Rezoning Transportation Analysis

Petition Number: 2020-150

Date	Description
11-30-20	First Review (EL)
12-28-20	Second Review (EL)

RZ1.0

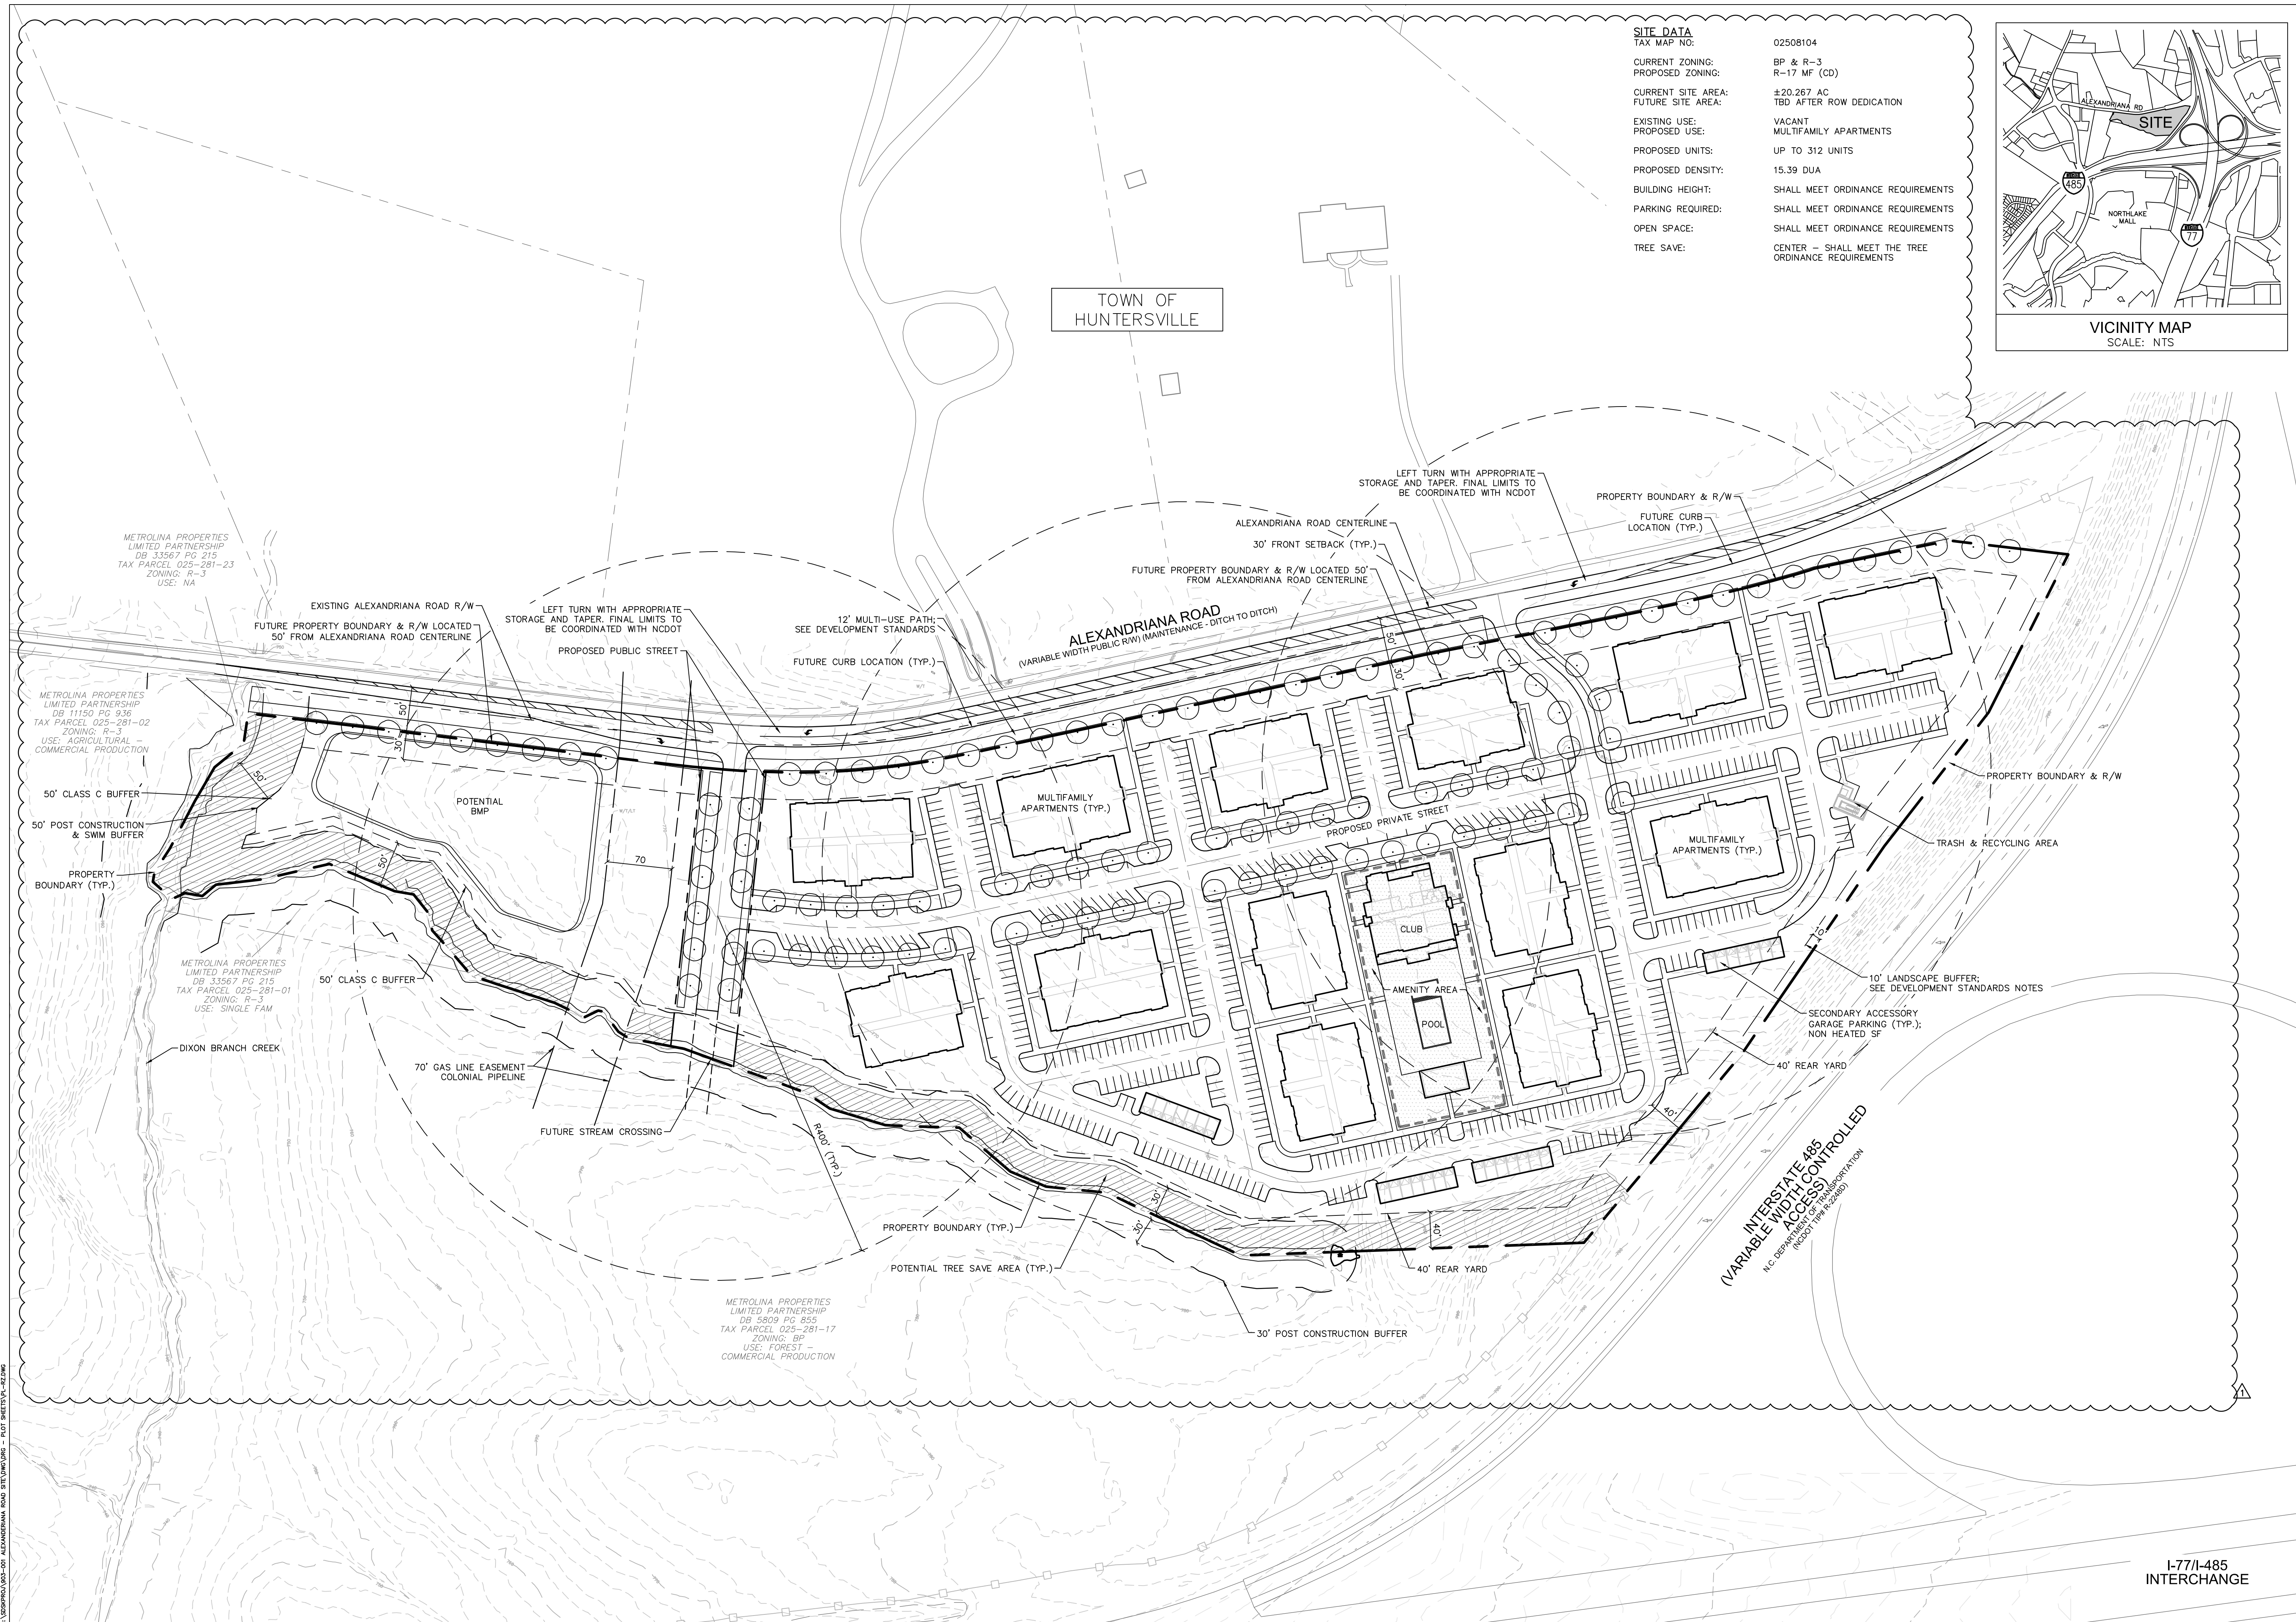
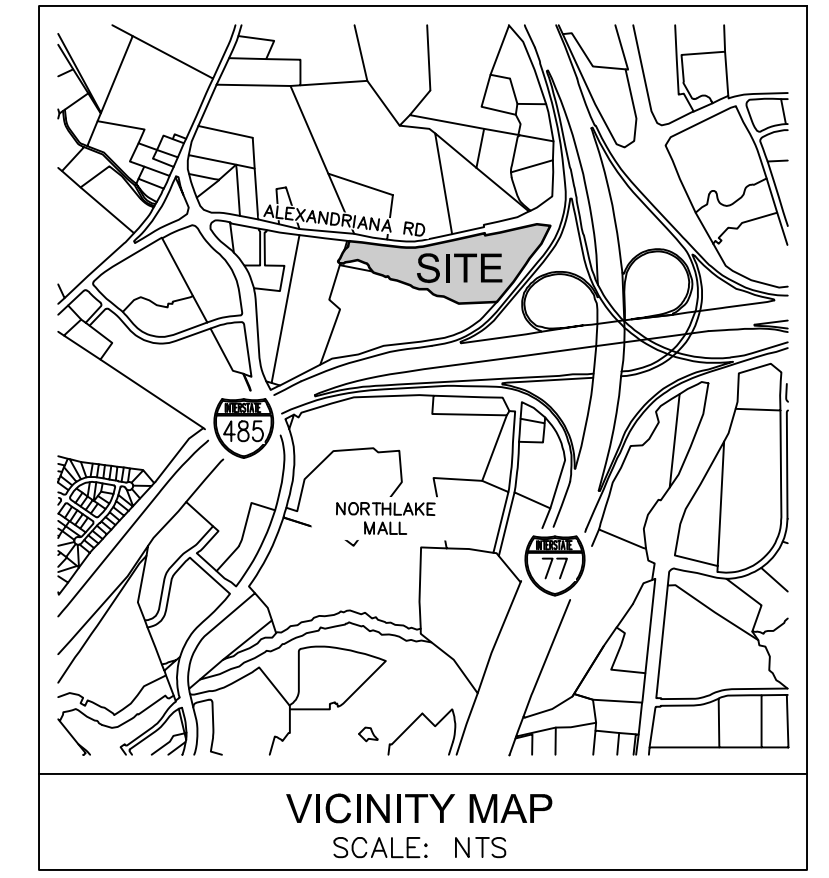
1. **Outstanding** (site plan dated 12.14.20) **Curbline:**

- a. **Alexandriana Road:** Location of curb and gutter needs to be installed at a location in coordination with NCDOT and CDOT. In reference to the North Lake Area Plan, the future cross section recommends a 4-lane divided facility with bike facilities. Coordinate with NCDOT (Stuart Basham) and CDOT to determine the right-of-way and asymmetric road widening needed for this future cross-section, while considering the following constraints: existing cemetery and Town of Huntersville jurisdiction limits to the north, future replacement/widening of Alexandriana Road bridge over I-77, etc. The total right-of-way width needed for this future cross section is 100-feet.

Label and dimension the curb and gutter from the centerline for each road on the site plan.

3. **Outstanding** (site plan dated 12.14.20) Revise the site plan and conditional note(s) to include the controlled-access (C/A) limits, to be provided by NCDOT.

CDOT requests a 12-foot shared use path. The site plan shall label and dimension both items from the back of curb and gutter and road centerline.

5. **Outstanding** (site plan dated 12.14.20) Revise the site plan and conditional note(s) to relocate the proposed access on Alexandriana Road to the private drive that is aligned with the proposed clubhouse, as permitted by sight distance constraints and NCDOT request to shift this access further away from the C/A limits.

6. **Outstanding** (site plan dated 12.14.20) Revise the site plan and conditional note(s) to restrict the proposed western access on Alexandriana Road to right-in/right-out, as required by NCDOT.
